Re: FG/210/18/PL – Case Officer Mr Z Denton

No 10 The Poplars, Ferring

Site Block Plan

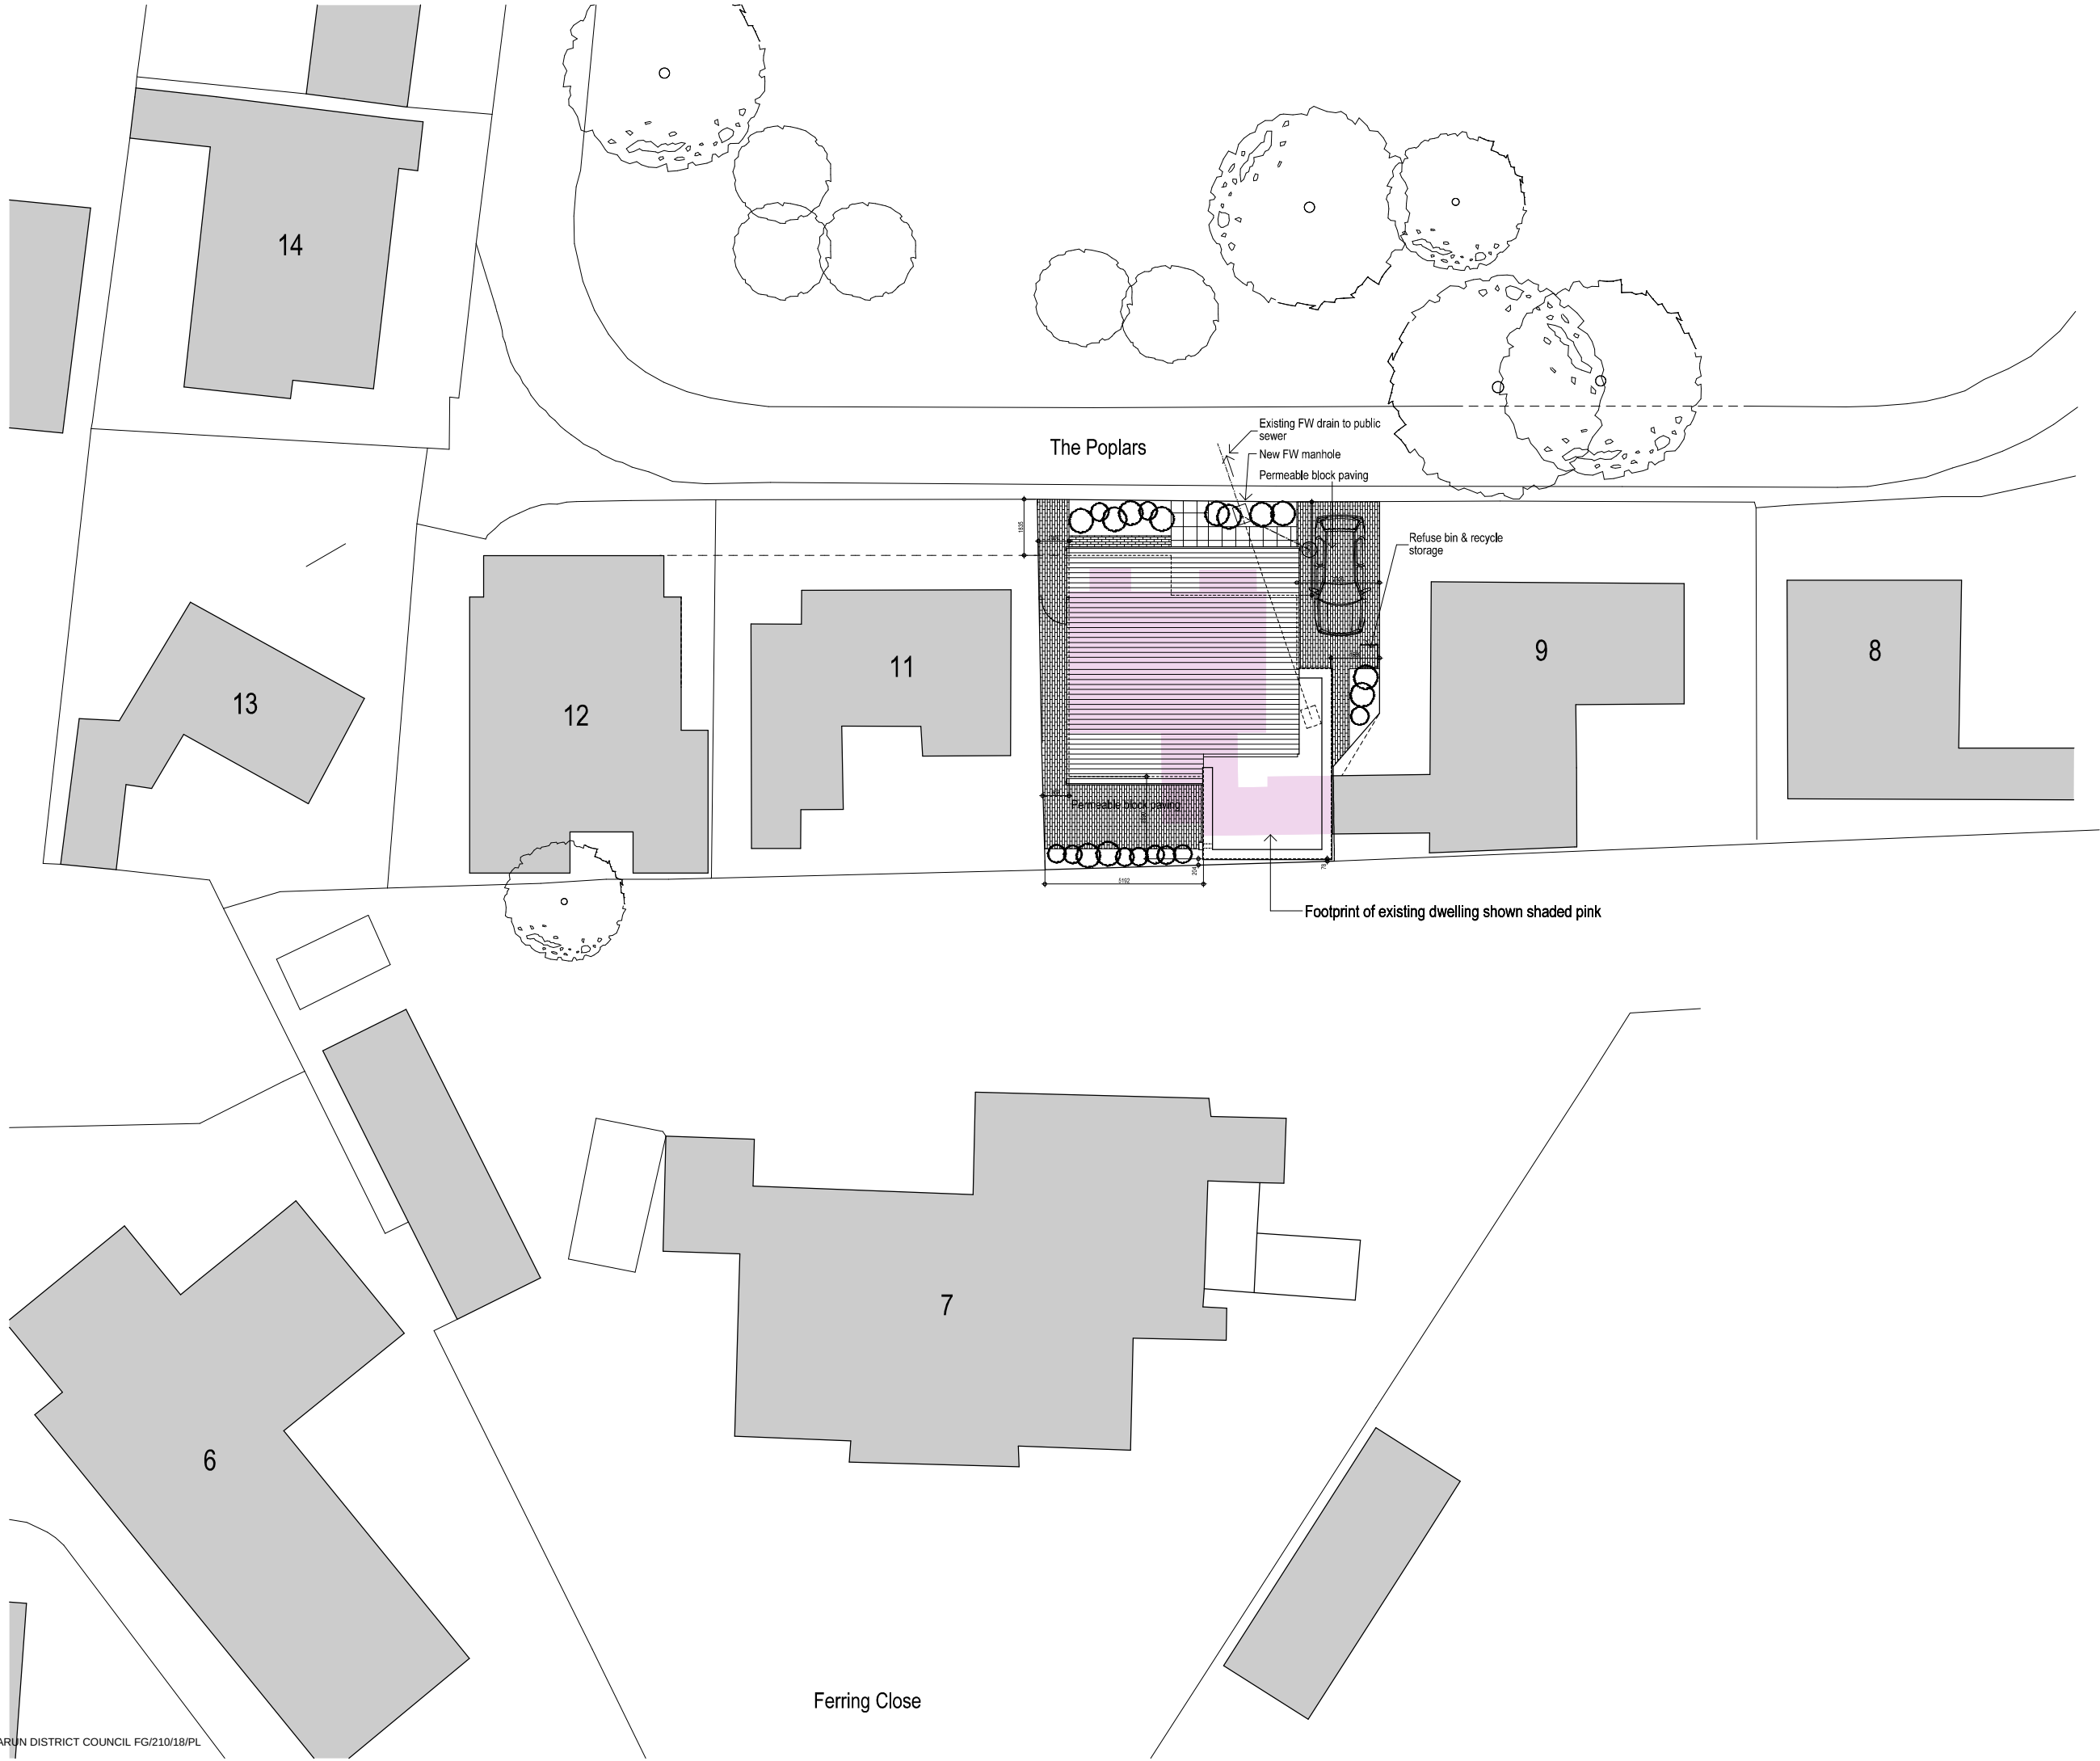
I have only quickly scanned the documents and found that there was no mention that No 9 and 10 are joined by some two metres of construction and a party wall agreement will be necessary.

Mr Snelling previously mentioned in our discussions that he proposed a walkway between the two buildings where they are presently adjoined. Whilst there is no dimensions on the new drawings it would seem reasonable that a gap should be provided such that both No 9 and No 10 can be maintained.
